Application H16-0331-26
Location 40 STONEGATE SPALDING PE11 2PH
Proposal Change the use from a 6 bed HMO (Class C4) to 7 bed HMO (Sui Generis)

Name Diane Gordon
Address SHDC Environmental Protection

SHEET NO.
P200
PROPOSED FLOOR PLANS

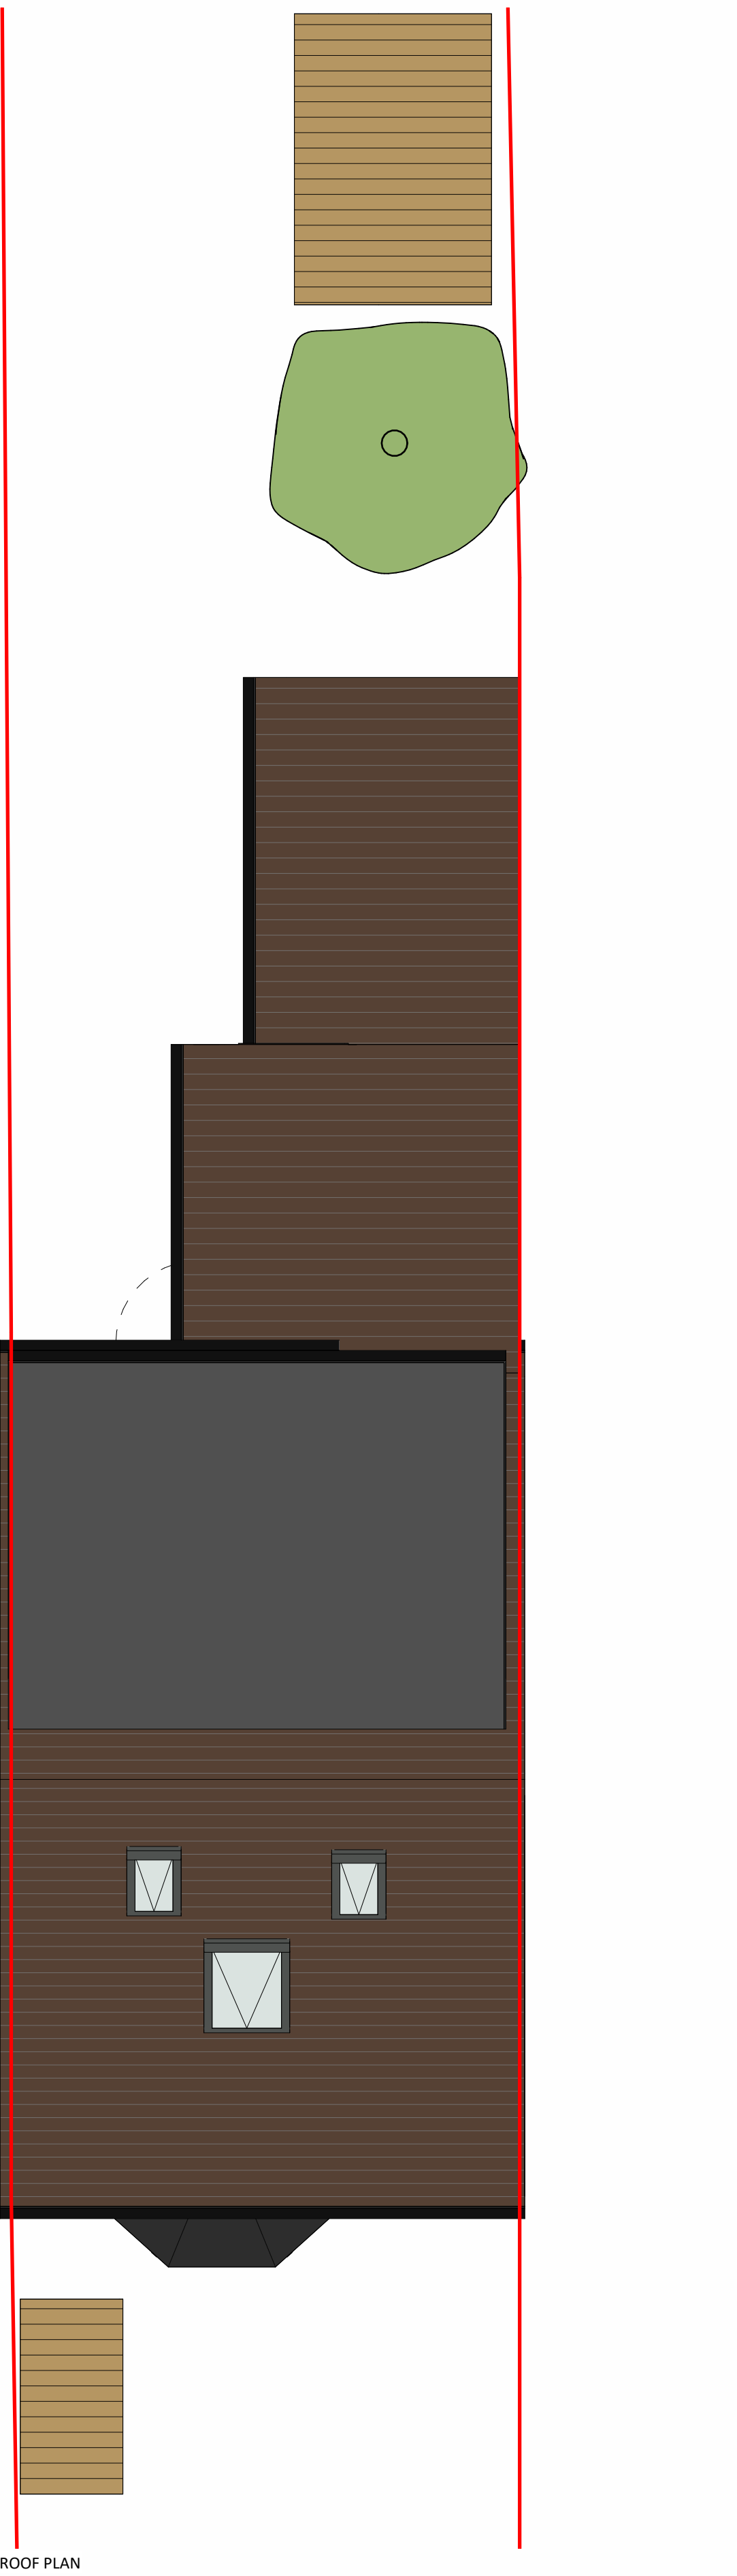
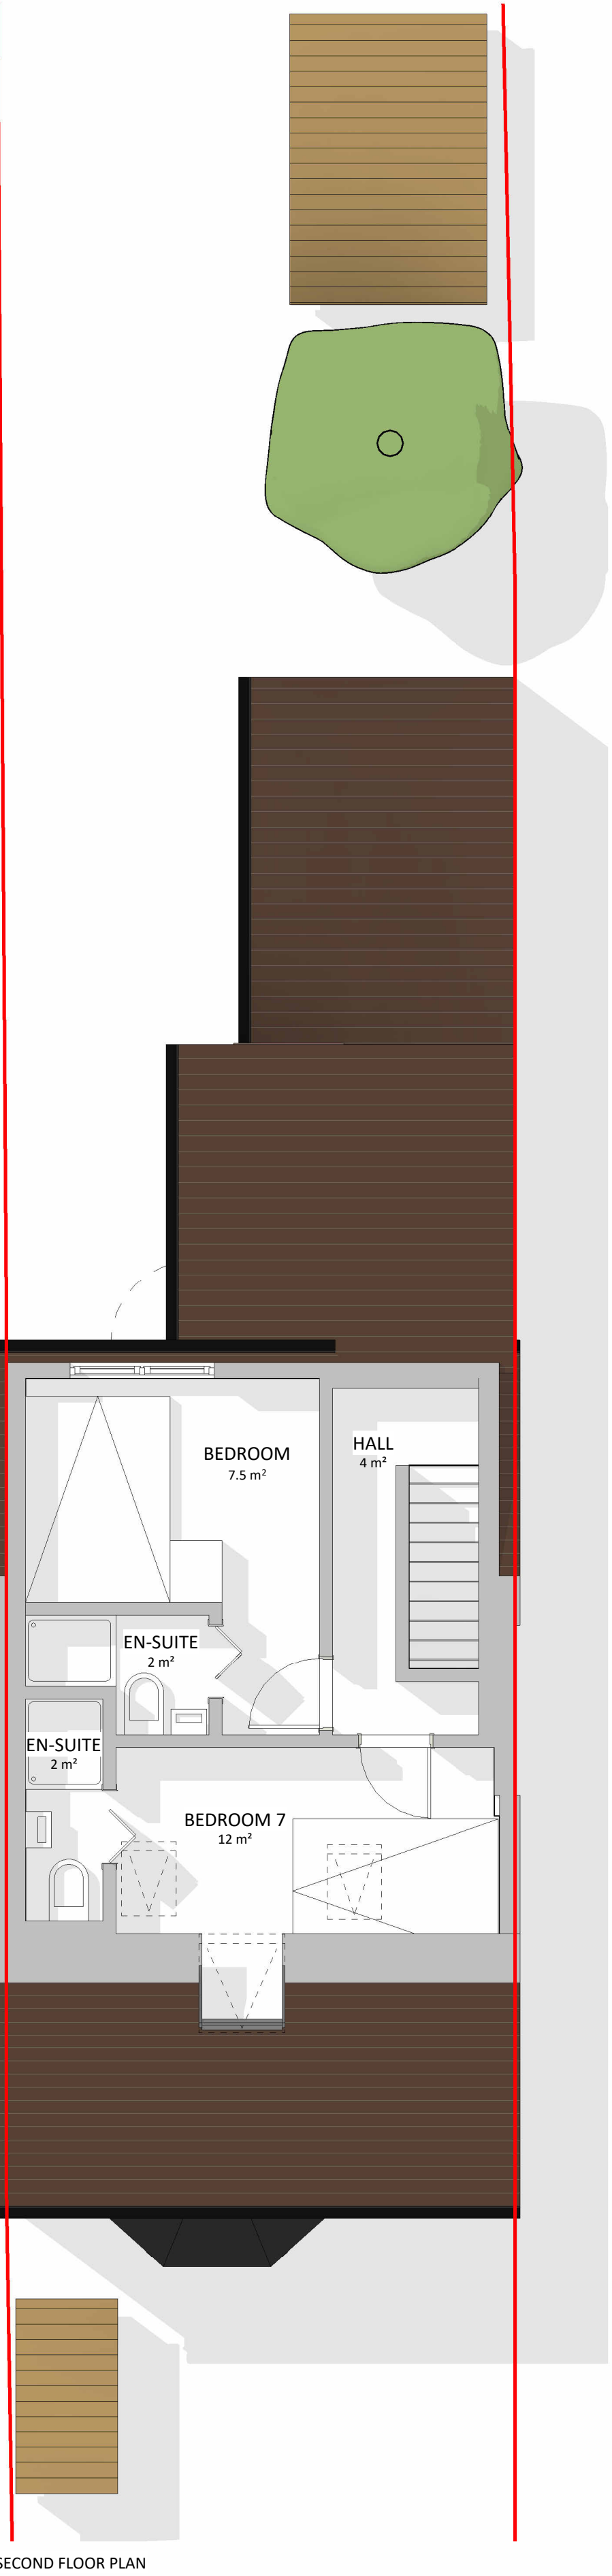
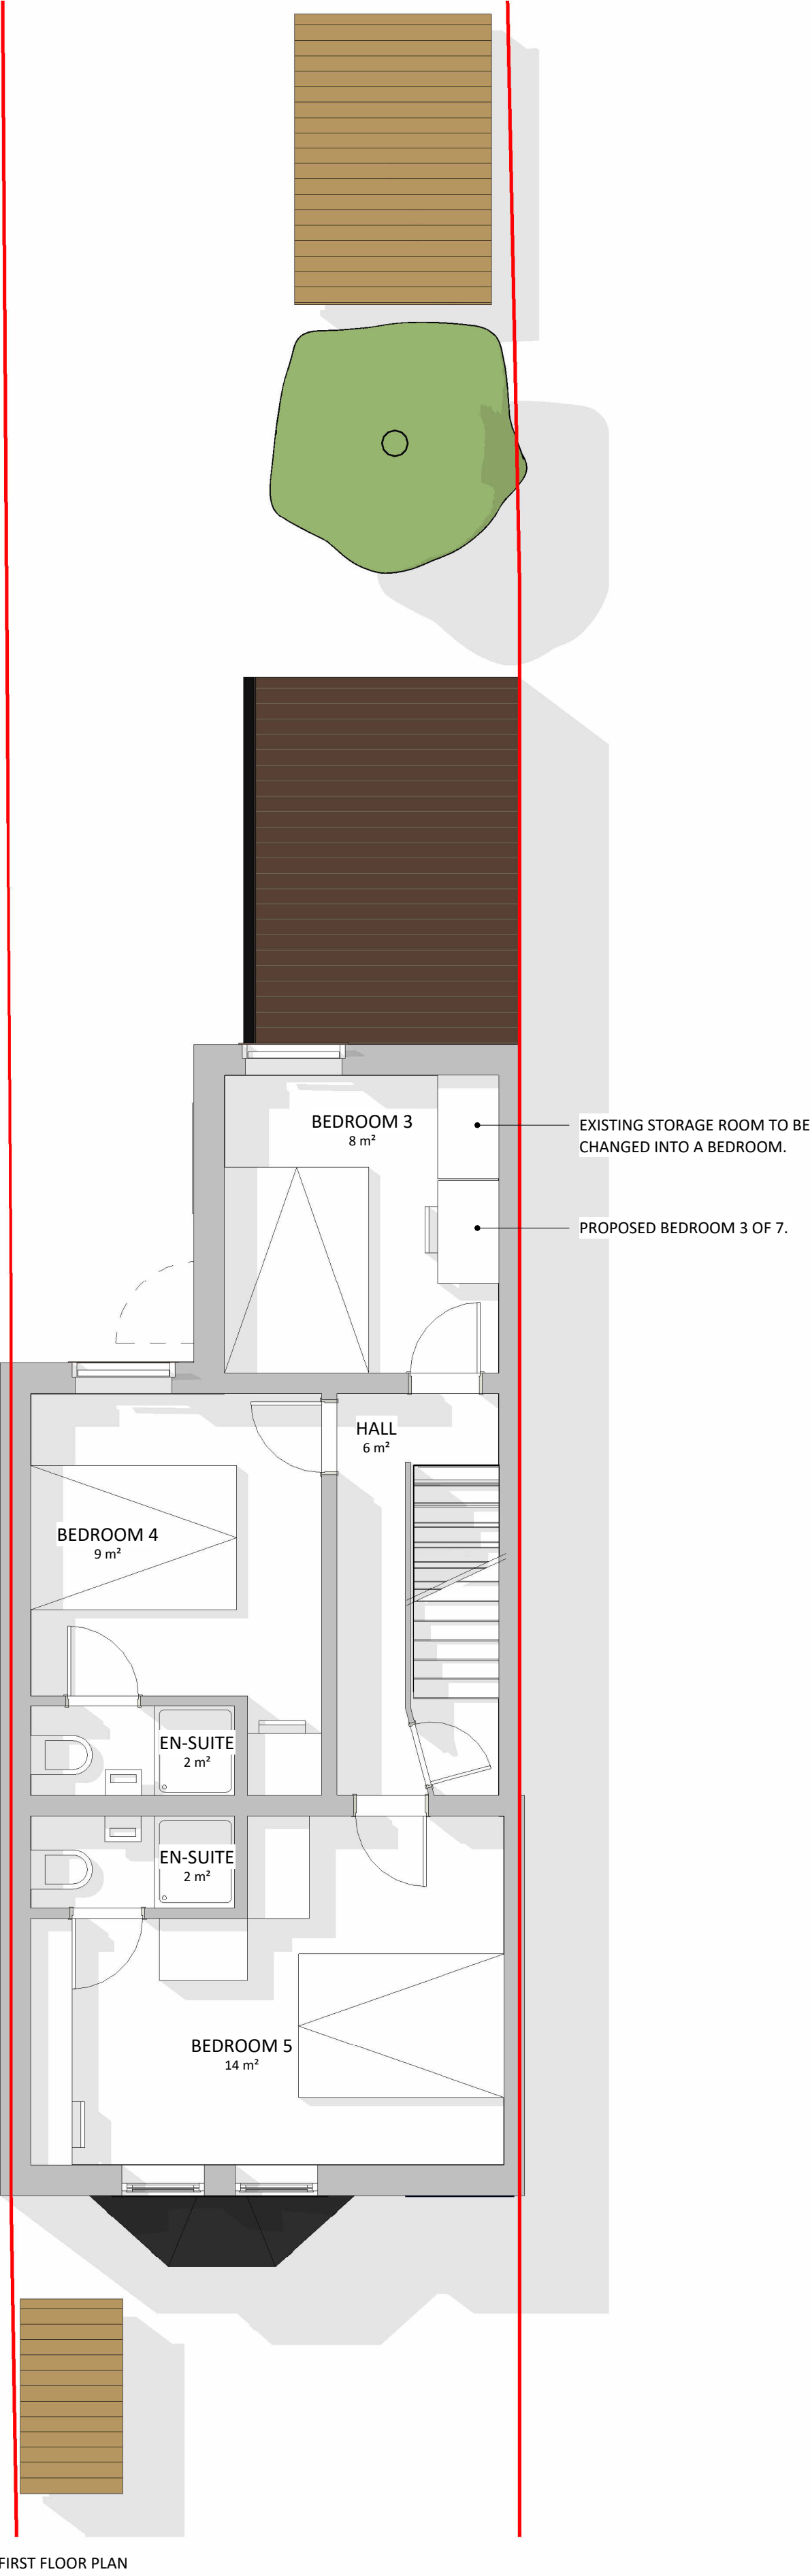
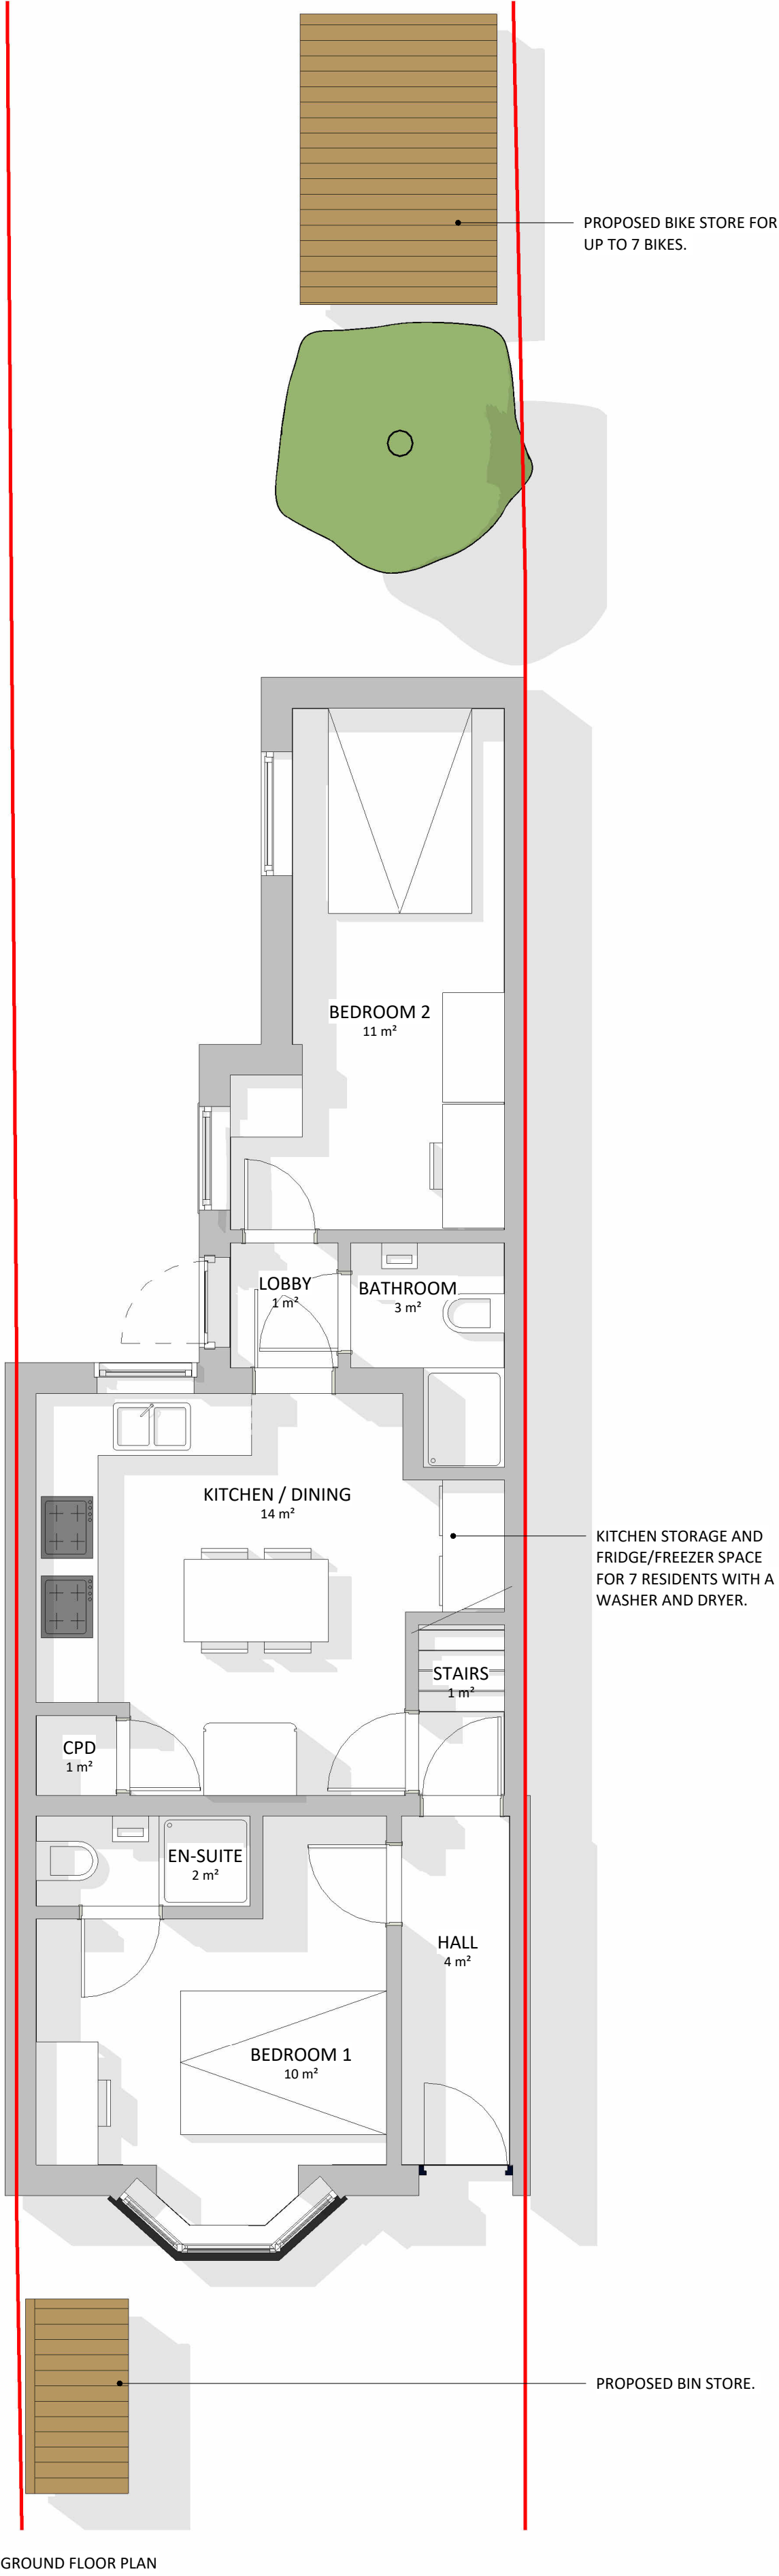
The property has recently been subject to complaints of poor management of waste likely to attract pests. additional occupants and reduces facilities for storage are unlikely to improve this situation. proper facilities for storage and management of waste must be included
